Director Infrastructure Projects
 Department of Planning and Environment
 Application Number: SSI 13_6136
 Major Projects Assessment
 GPO Box 39
 SYDNEY NSW 20001

10 September 2014

Re: NorthConnex (M2-M1 Connection) Project - Application No: SSI 13_6136

8.0 Landscape Design

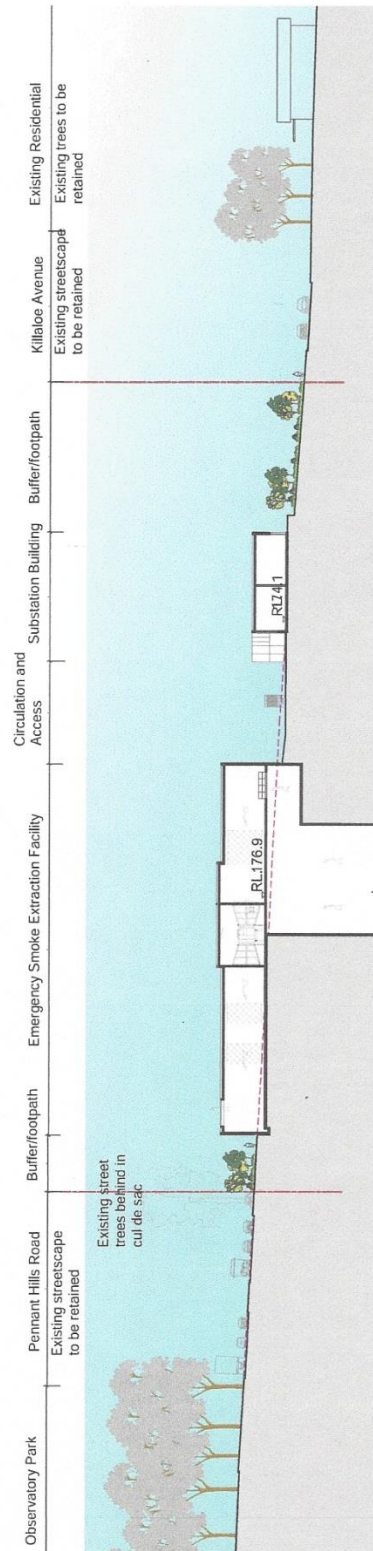
16.1 Section 7.5-Urban design, landscape character and visual amenity (p.659) states that there will be overshadowing of the adjacent properties in winter however, the shadow diagram (M1-M2-5000-DR-UD-0903) shows no such overshadowing. Further, examination of this shadow diagram shows that it has been prepared for the wrong date and is inaccurate. Shadow diagrams are normally prepared for 9am, 12 noon and 3pm on 21 December and 21 June. No diagram for 21 December has been provided. Diagrams for 21 March and 21 September, the autumn and spring equinoxes, are generally only required where there is to be substantial overshadowing or the overshadowing does not comply with the consent authorities guidelines. The supplied shadow diagram is also incorrect. The site has a directly east-west orientation. With the sun rising in the east, moving through an arc to the north, and setting in the west, it is almost impossible for shadows to be cast to the north at midday as indicated on the supplied plans. Additionally, examination of the shadows which occur on the underlying aerial photograph clearly show no correlation to the shadows predicted by the diagram. Regardless of at what time of day or what season the aerial photograph was taken, there should be some correlation to the predicted shadows in at least one of the 3 supplied diagrams.

Proposed Action: Preparation of shadow diagrams for 21/12 and 21/6) which accurately plot the shadows of both the 'temporary' construction buildings and the final operational buildings. These diagrams should be provided to residents for their comment prior to consent being granted.
